Our ref: JH:LC:97032

13 December 2012

**SUBMISSION
PRINCES HIGHWAY UPGRADE – FOXGROUND AND BERRY BYPASS
APPLICATION NUMBER: 10_0240**

Figure 4-3 Section 3 (Northern interchange for Berry to Mullers Lane)

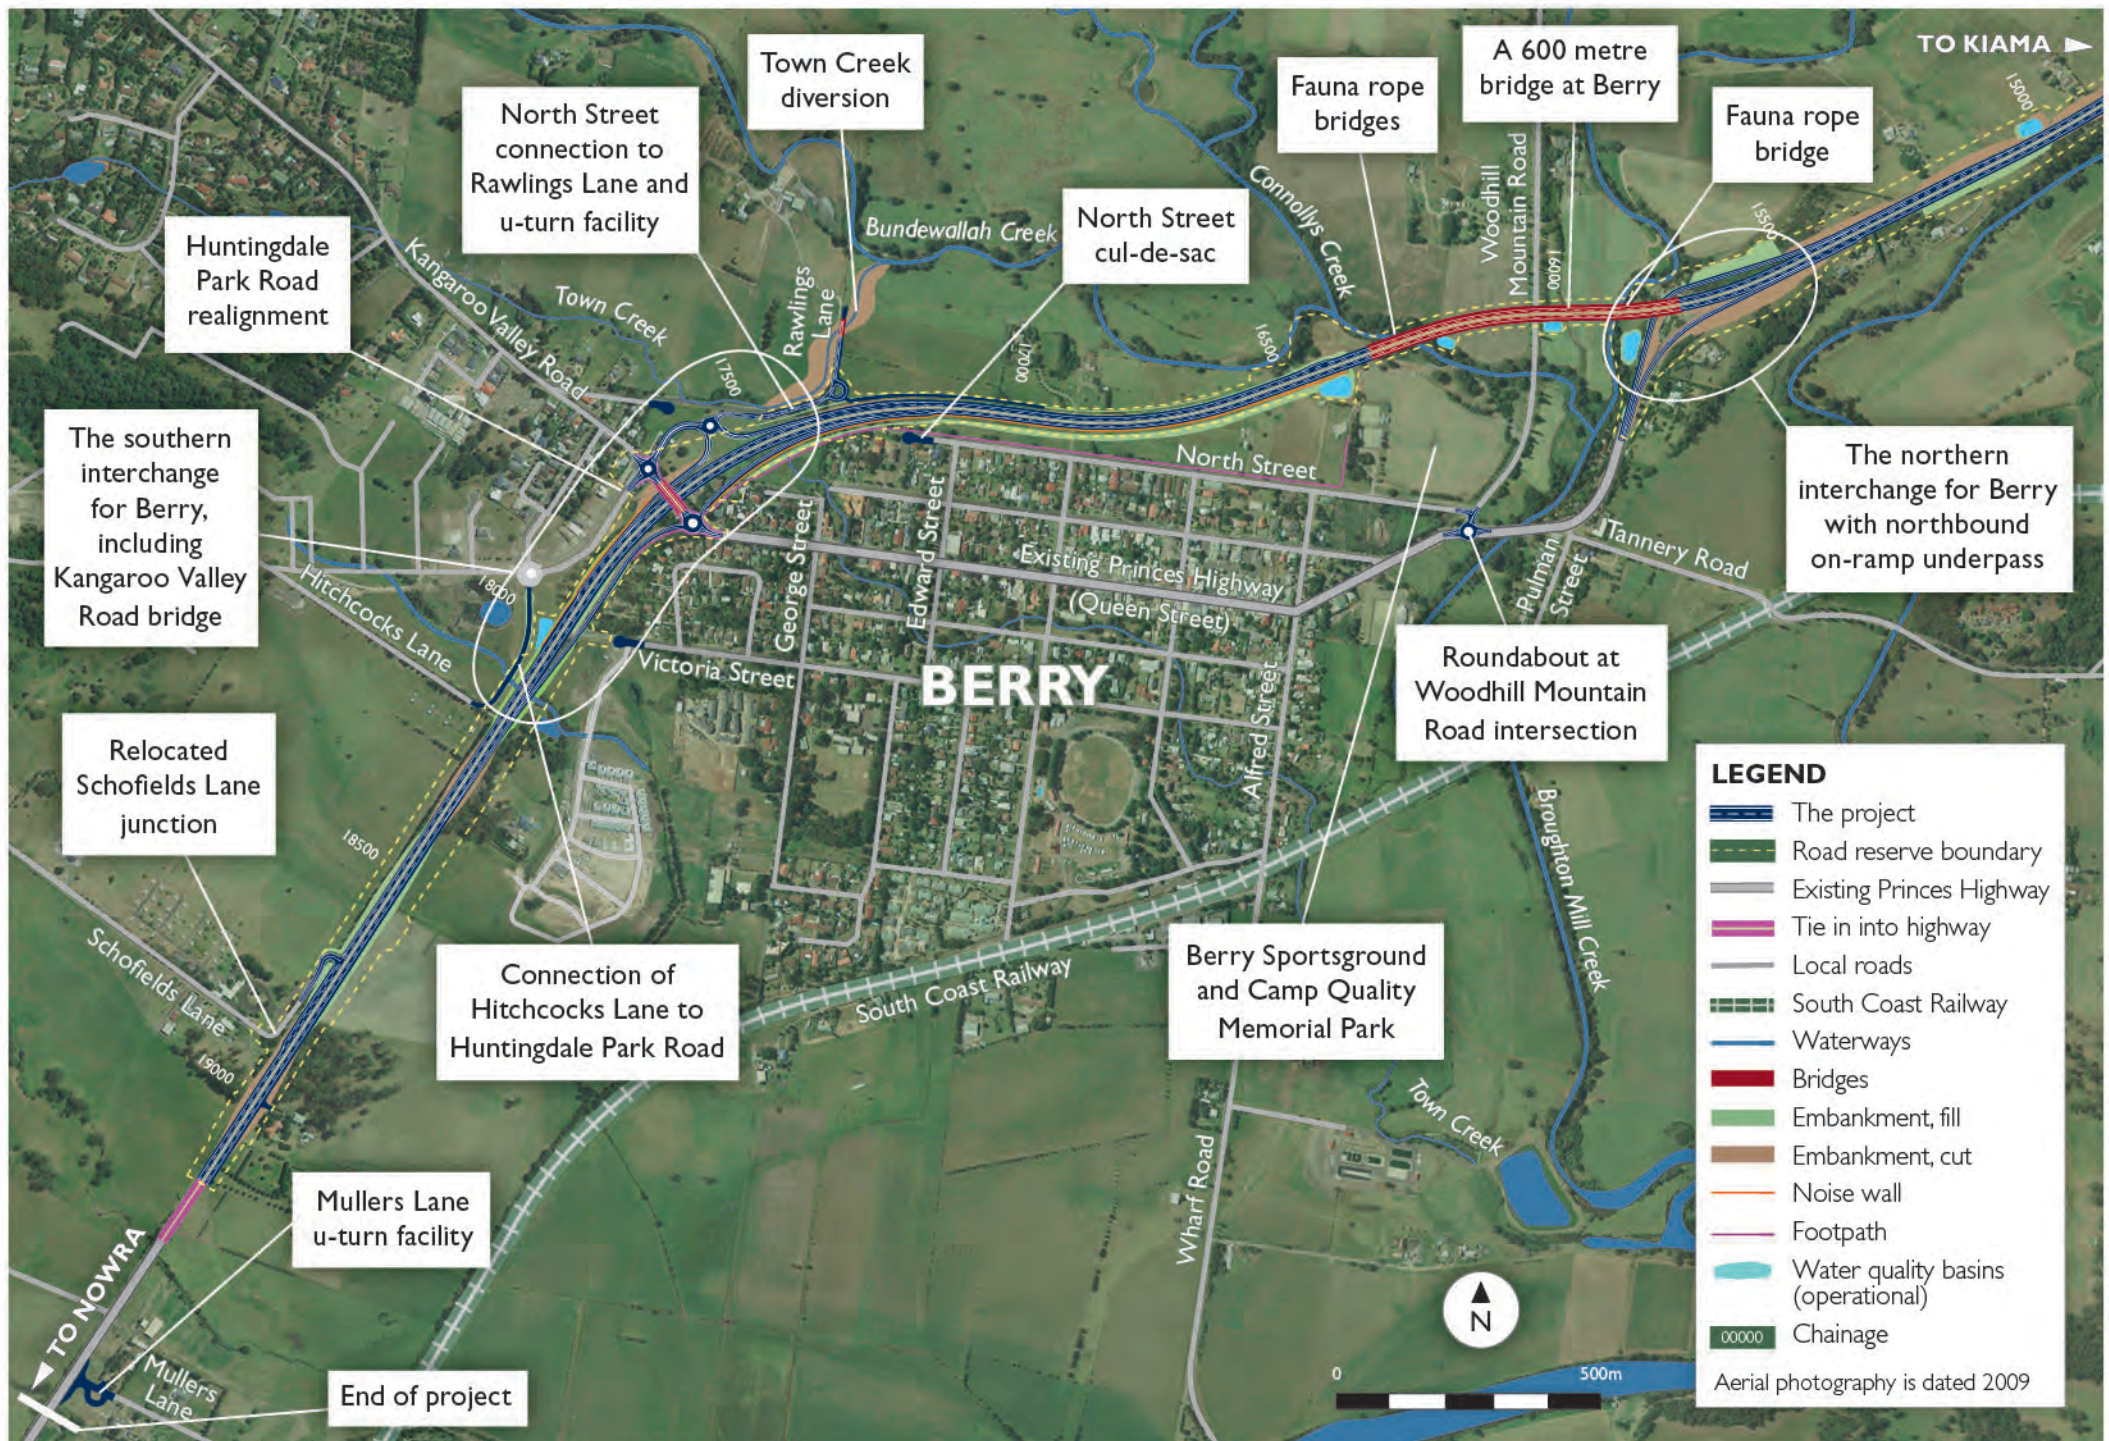
It is my understanding from proposals which I have seen that the Department is constructing the Berry Bypass and that one element of this proposal is that there will be no access to Schofields Lane from the Highway for traffic travelling in a southerly direction. Rather, I gather that it is proposed that there will be a turning circle for traffic travelling along the Highway in a southerly direction at Mullens Lane which will provide access, although indirectly, to Schofields Lane.

Mr Ipkendanz's concern is that the turning circle on the proposed new access arrangements will be of insufficient size to enable access and exit for the trucks that are required to go to his property to deliver and collect cattle, including 25 meter BDouble trucks. Enquiries which have been made on behalf of Mr Ipkendanz confirm that a 25 meter BDouble truck requires a minimum turning radius of 15 meters at a speed of 5-15 kilometers per hour.

Details of the proposed turning circle are not apparent from the material which is online, and I am writing to seek confirmation from the Department that the proposed turning

circle will be so constructed as to provide for a turning radius of 15 meters as this is the minimum that is required to enable Mr Ipkendanz to continue to carry on his long established rural activities on his property.

Could you please acknowledge receipt of this submission and provide confirmation that the proposed turning circle will have a minimum turning radius of 15 meters.
